City of Portland, Maine - Building or Use Permit Application
 389 Congress Street, 04101 Tel: (207) 874-8703, Fax: (207) 874-8716

Permit No: 04-1000	Issue Date:	CBL: 188 C039001
------------------------------	--------------------	----------------------------

Past Use: Single family home w/ detached 2 car garage	Proposed Use: Single family home w/ attached 16'x16' breezeway & garage	Permit Fee: \$471.00	Cost of Work: \$50,000.00	CEO District: 3
Proposed Project Description: Build 16'x16' breezeway to connect house and existing 28'x32' garage		FIRE DEPT: <input type="checkbox"/> Approved <input type="checkbox"/> Denied	INSPECTION: Use Group: Type	
		Signature:	Signature:	
PEDESTRIAN ACTIVITIES DISTRICT (P.A.D.)				
Action: <input type="checkbox"/> Approved <input type="checkbox"/> Approved w/Condition <input type="checkbox"/> Denied				
		Signature:	Date:

PLOT PLAN 1" = 10'

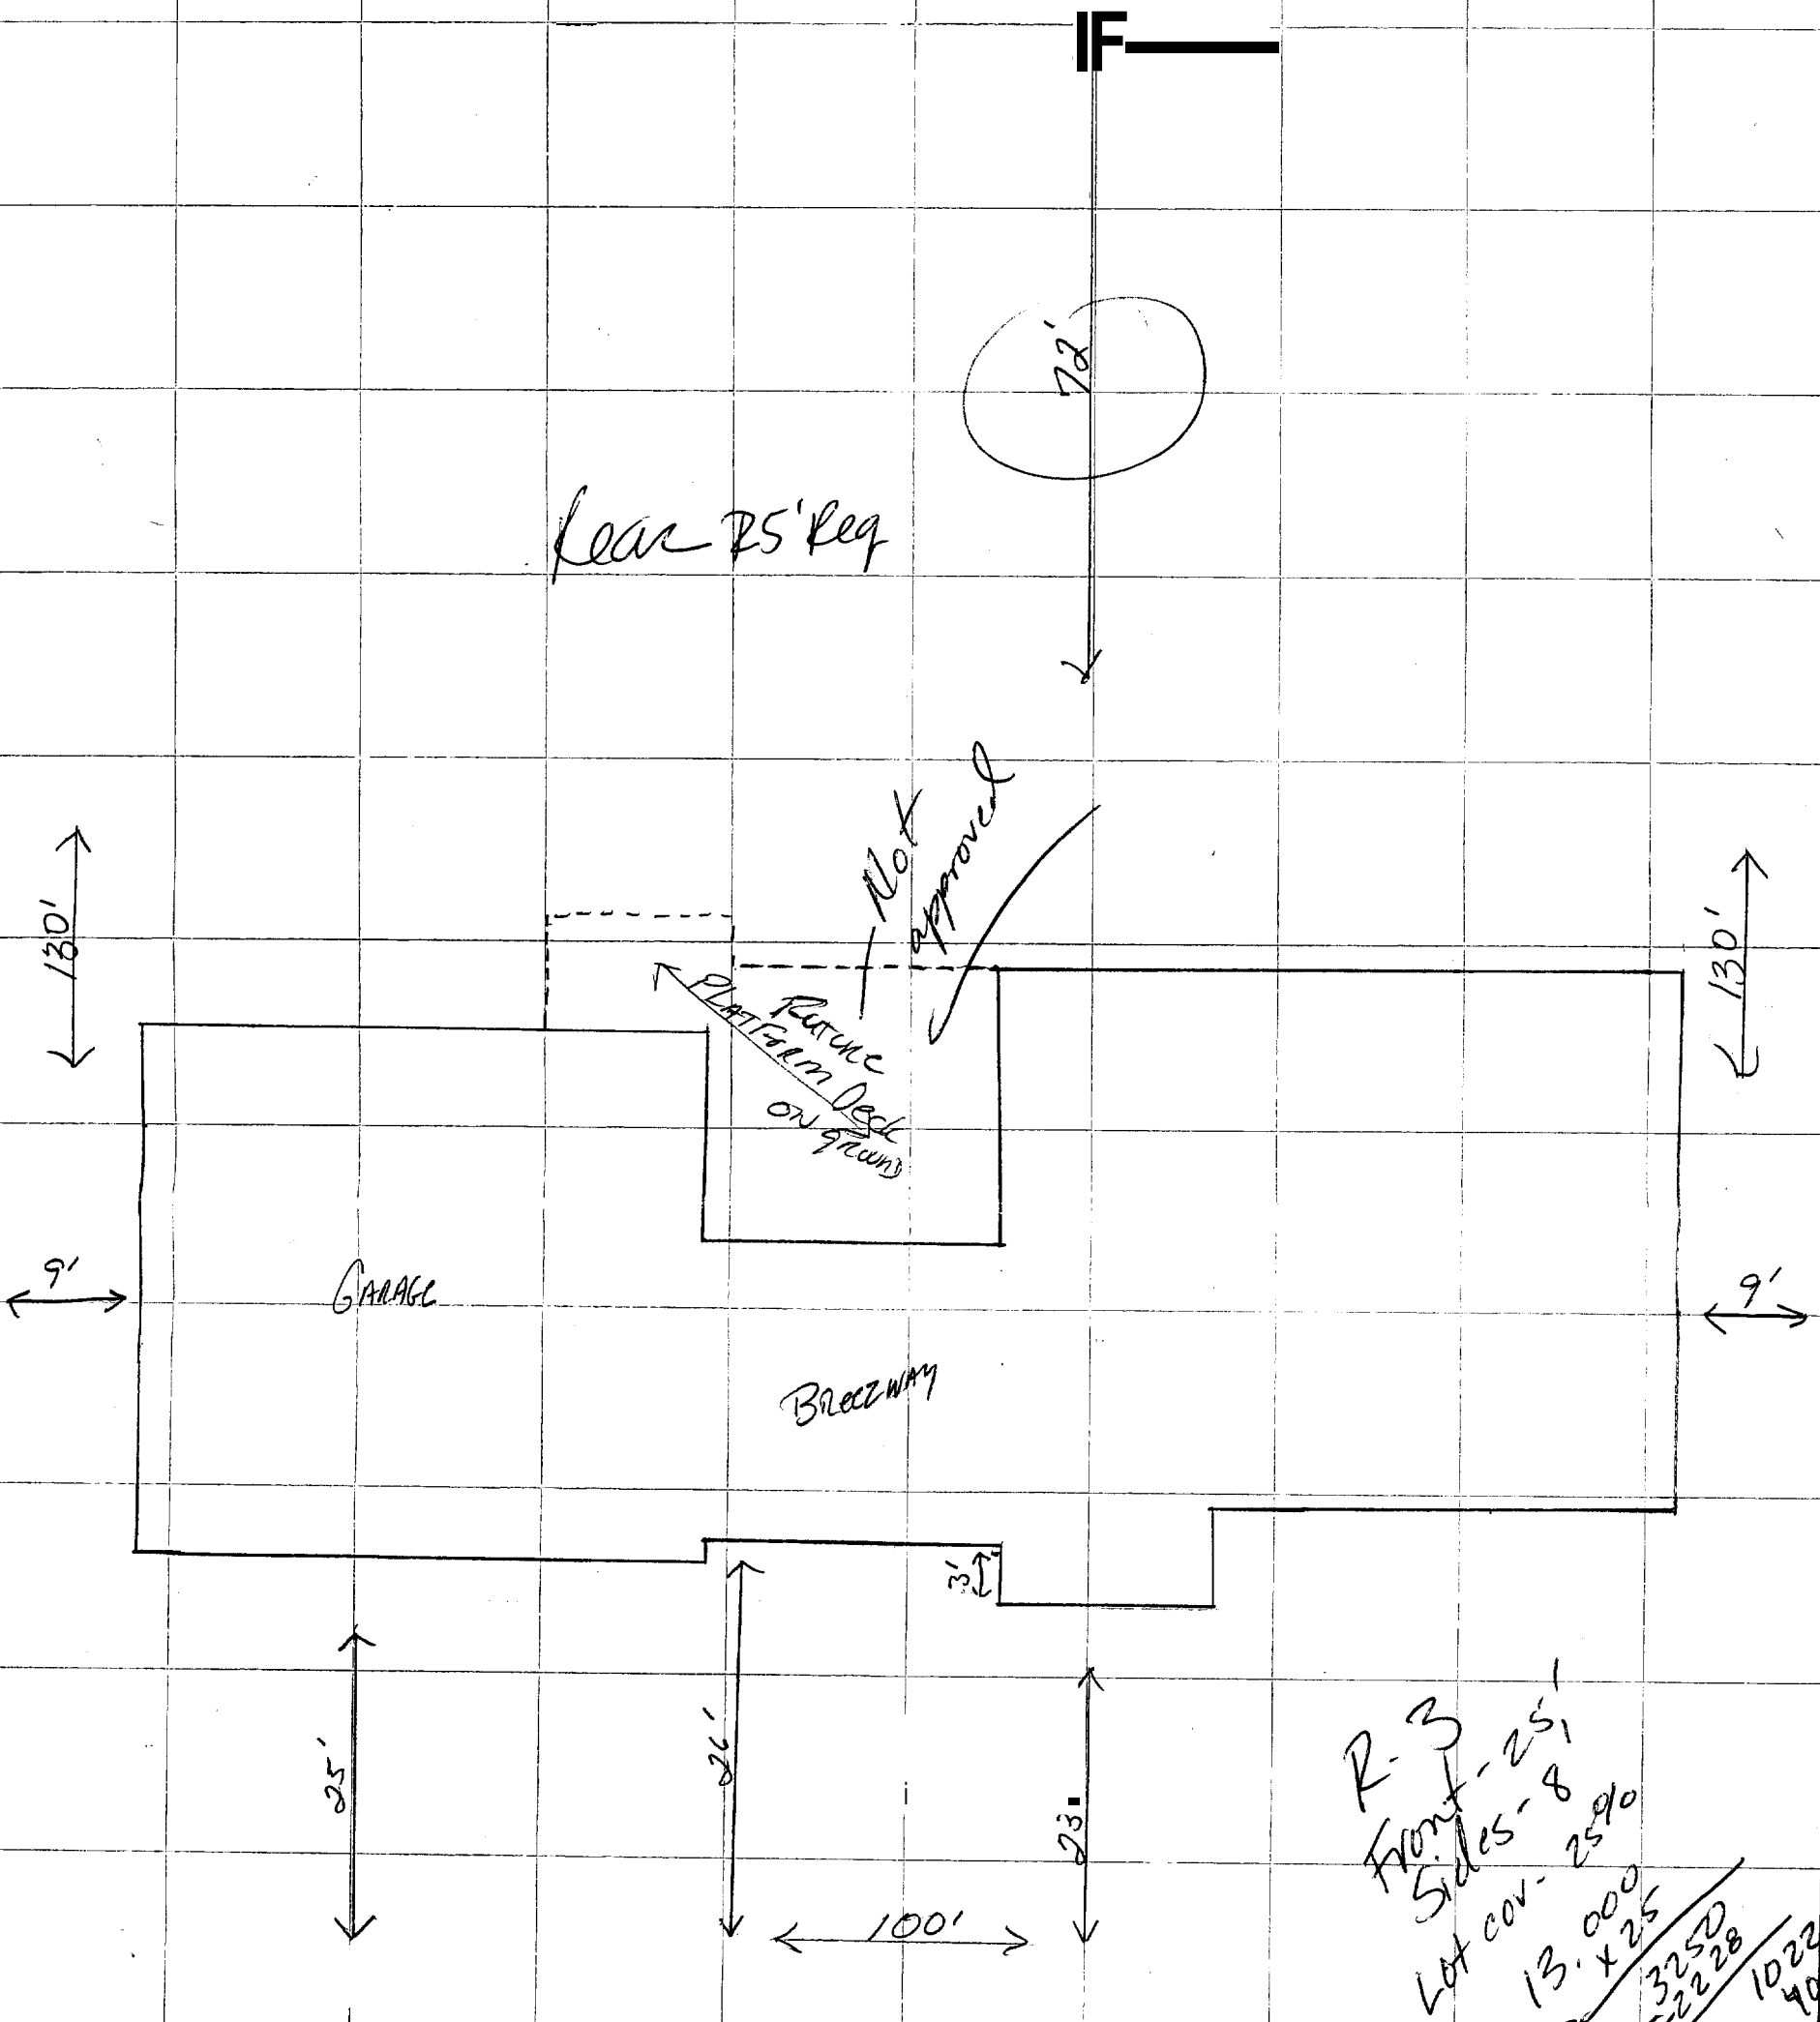
Comments:
7/28/04-tmm: need ccomplete plot plan - called owner and spoke to her.
8/10/04-tmm: Called owner and told her mortgage survey is not drawn correctly - there is 10' missing. She said she would stake her property line and give me dimensions for the front setback.
8/11/04-tmm: Met w/property owners and reviewed what setbacks are required in the area. They will revise plans and resubmit.
8/27/04-tmm: ok to issue - revised site plan to meet.
